Sunnica Ltd
2 Crossways Business Centre
Bicester Road
Aylesbury
HP18 0RA

21st January 2022

Application for a Development Consent Order for Sunnica Energy Farm

RE: Advice following issue of decision to accept the application for examination

THIS DRAWING IS TO BE USED ONLY FOR THE PURPOSE OF ISSUE THAT IT WAS ISSUED FOR AND IS SUBJECT TO AMENDMENT

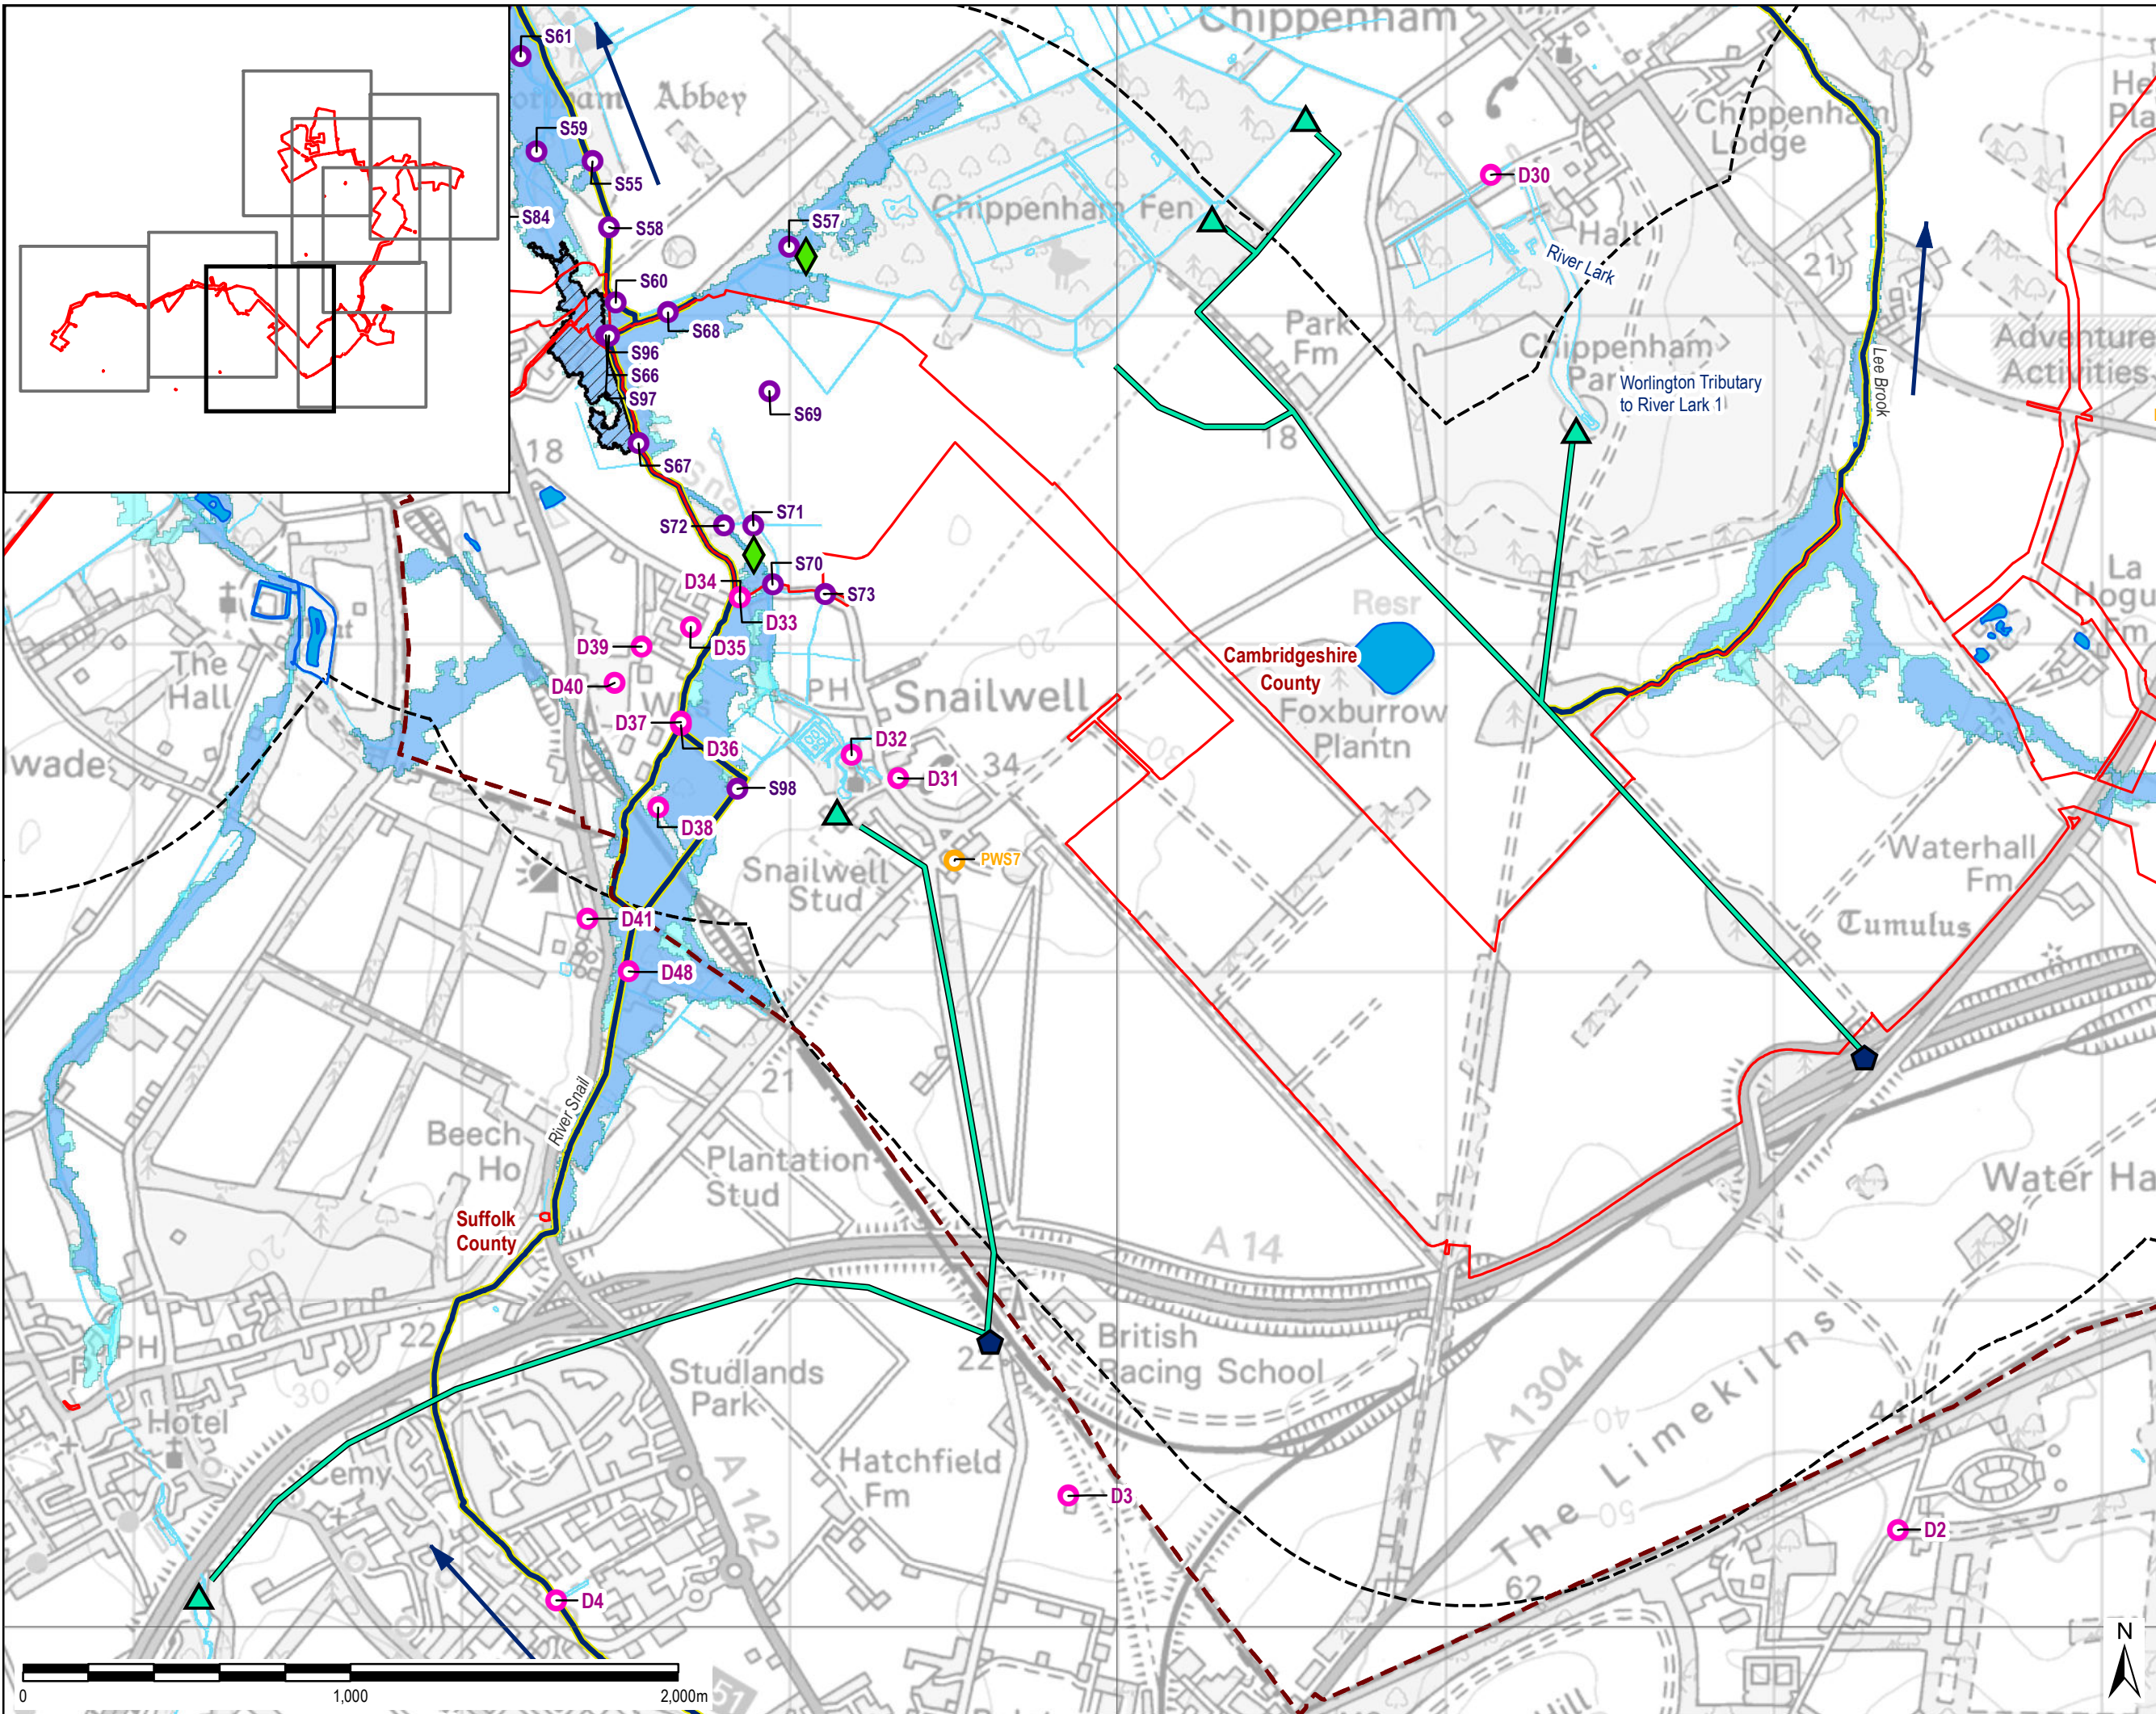
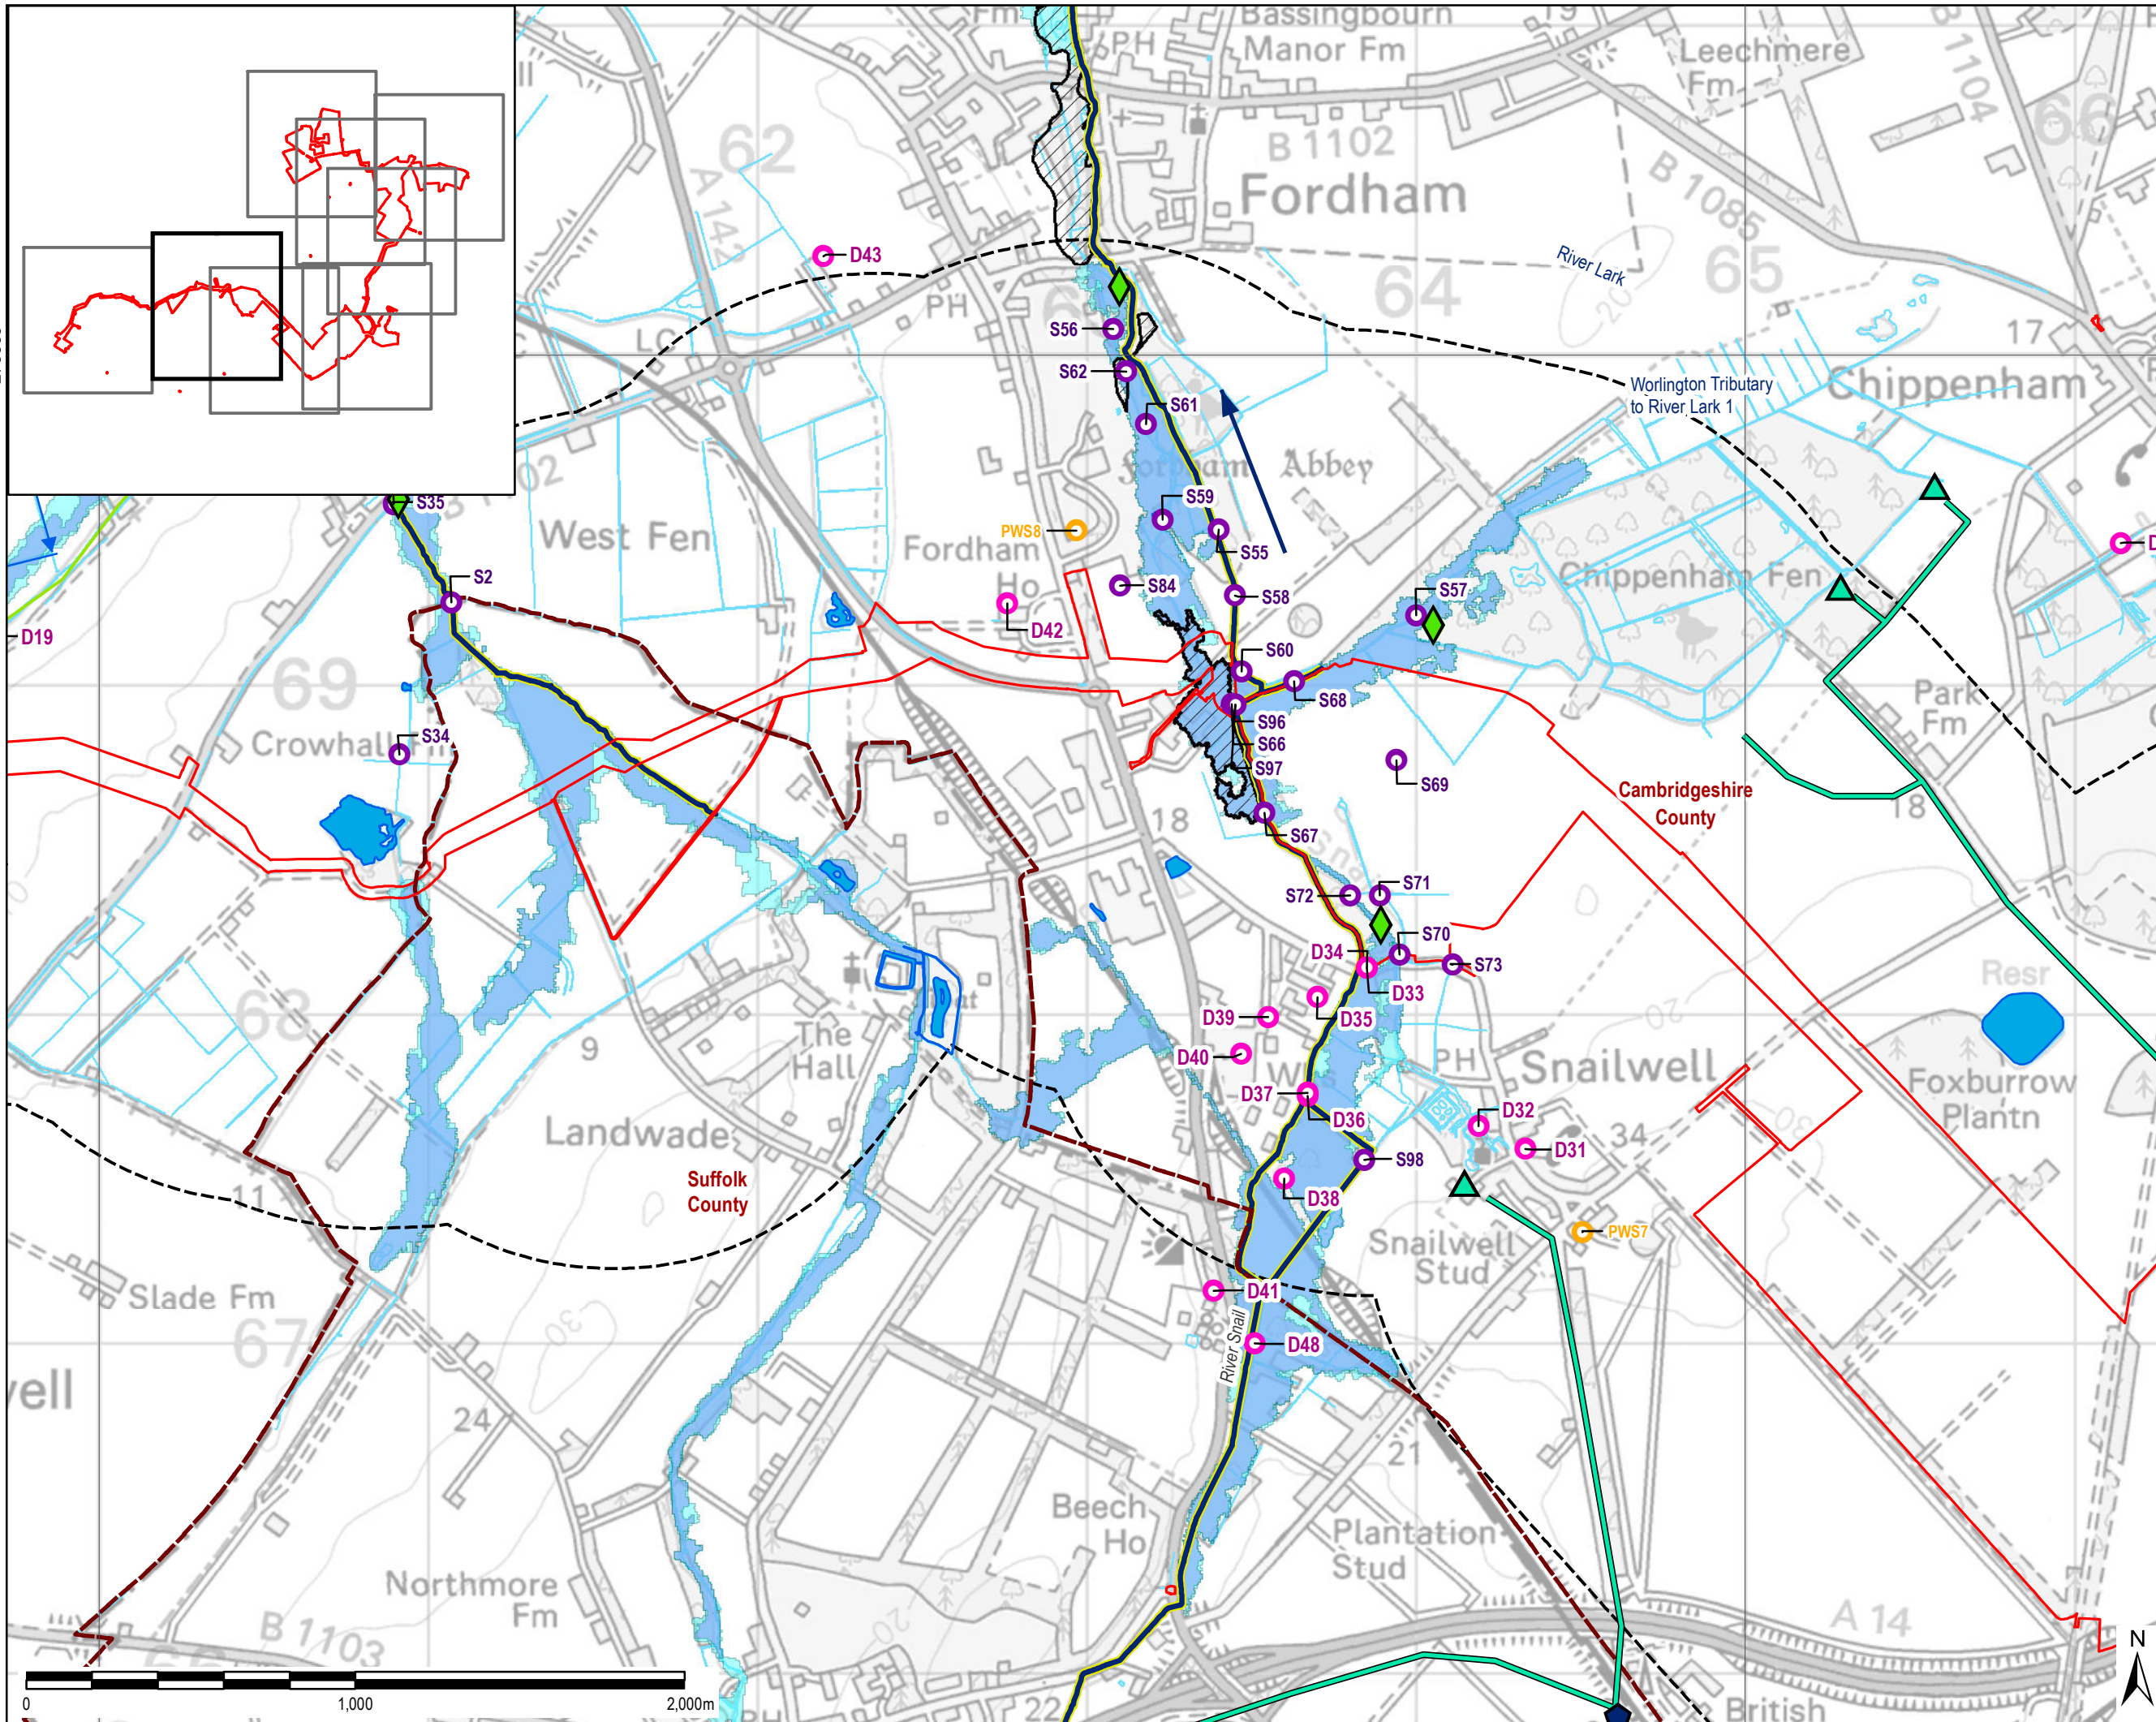
- 1.4.3 Revision 1 of Figure 9-1 of the Environmental Statement [APP-188] is provided to address the advice provided by the Planning Inspectorate.
